OXFORDSHIRE COUNTY COUNCIL'S RESPONSE TO CONSULTATION ON THE FOLLOWING DEVELOPMENT PROPOSAL

Application no: 21/03266/F

Proposal: Site clearance, construction of new site access from the B4100, permanent and temporary internal roads, an internal roundabout and a foul drainage station, diversion of an existing overhead power cable and public right of way, and soft landscaping

Location: OS Parcel 2636 NW Of Baynards House, Ardley

Site Access Details

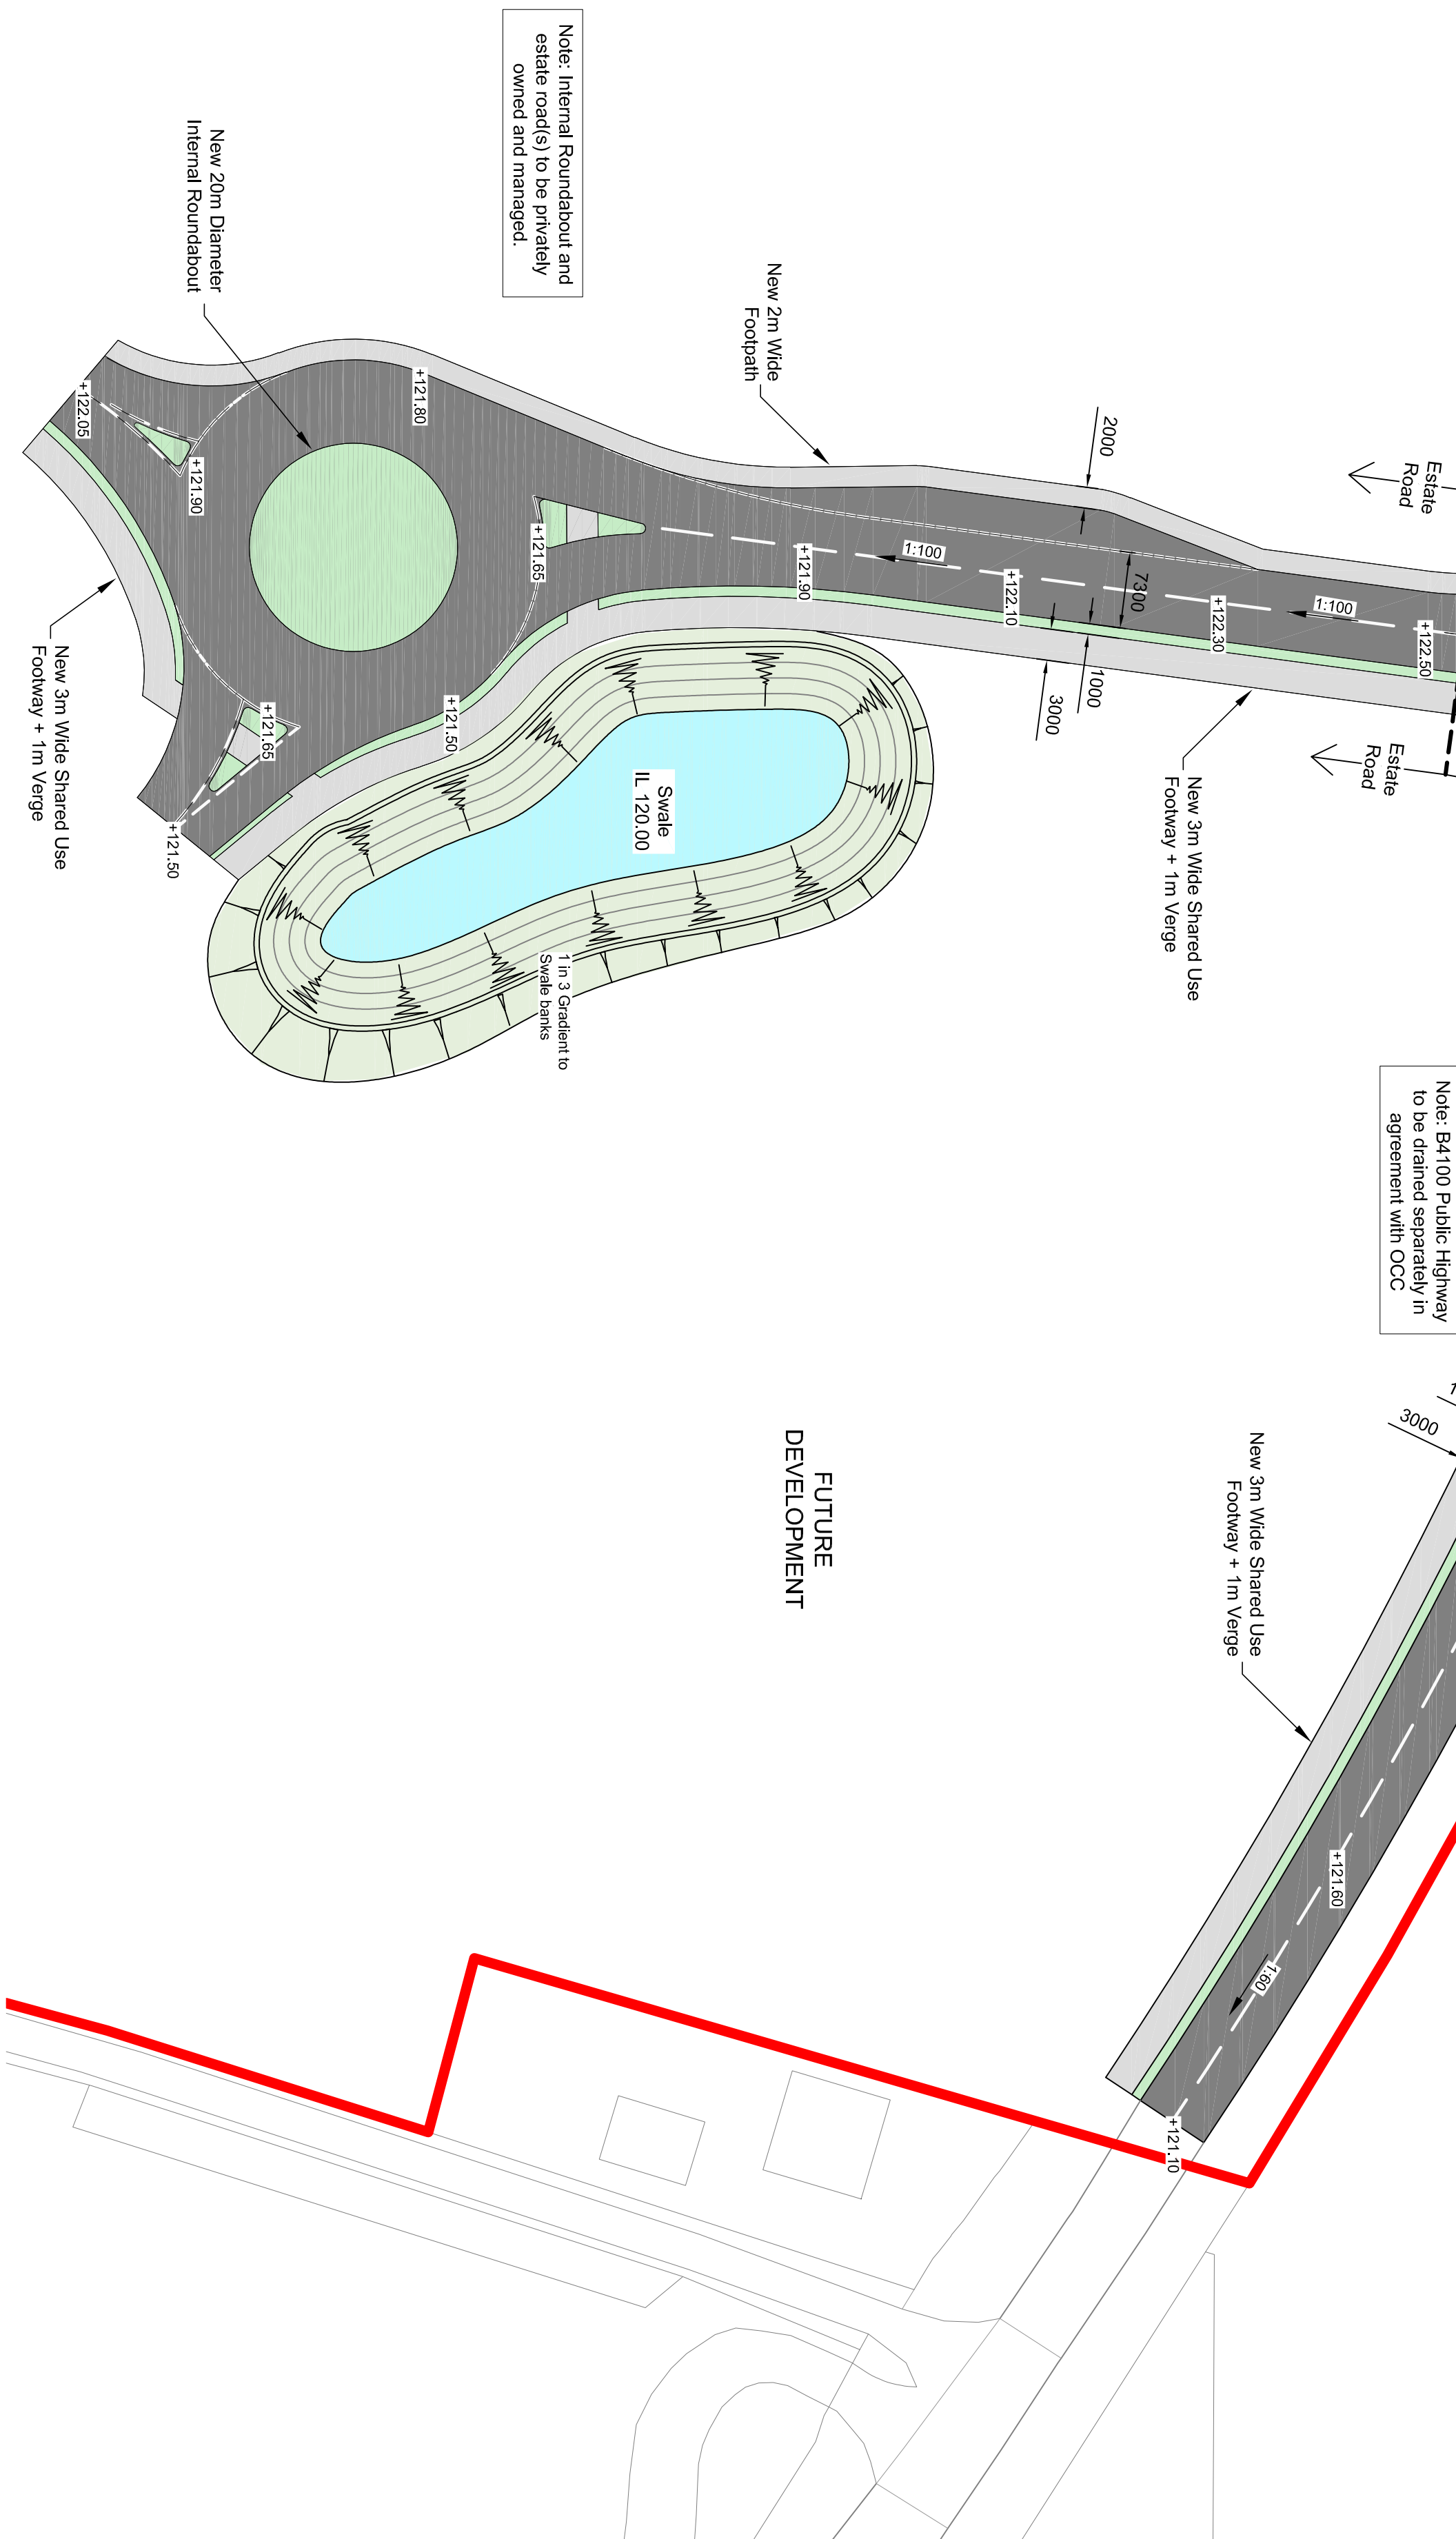
A new roundabout junction is proposed onto the B4100. A drawing has been provided showing how this meets DMRB standards. However, OCC has concerns about the straightness of the approaches on the B4100, especially given the national speed limit. Experience of similar layouts of recently constructed roundabouts on high speed roads has shown that some drivers fail to appreciate the roundabout until the last minute, leading to collisions or driving over the roundabout. Further work is needed to adjust the alignment of the B4100 on approaches. This is challenging due to the land on the northern side of the B4100 not being available. This has not been picked up in the Road Safety Audit provided, but OCC would welcome further discussions given their experiences elsewhere. Consideration could be given to a reduction in the speed limit along the site frontage extending to Baynards Green roundabout.
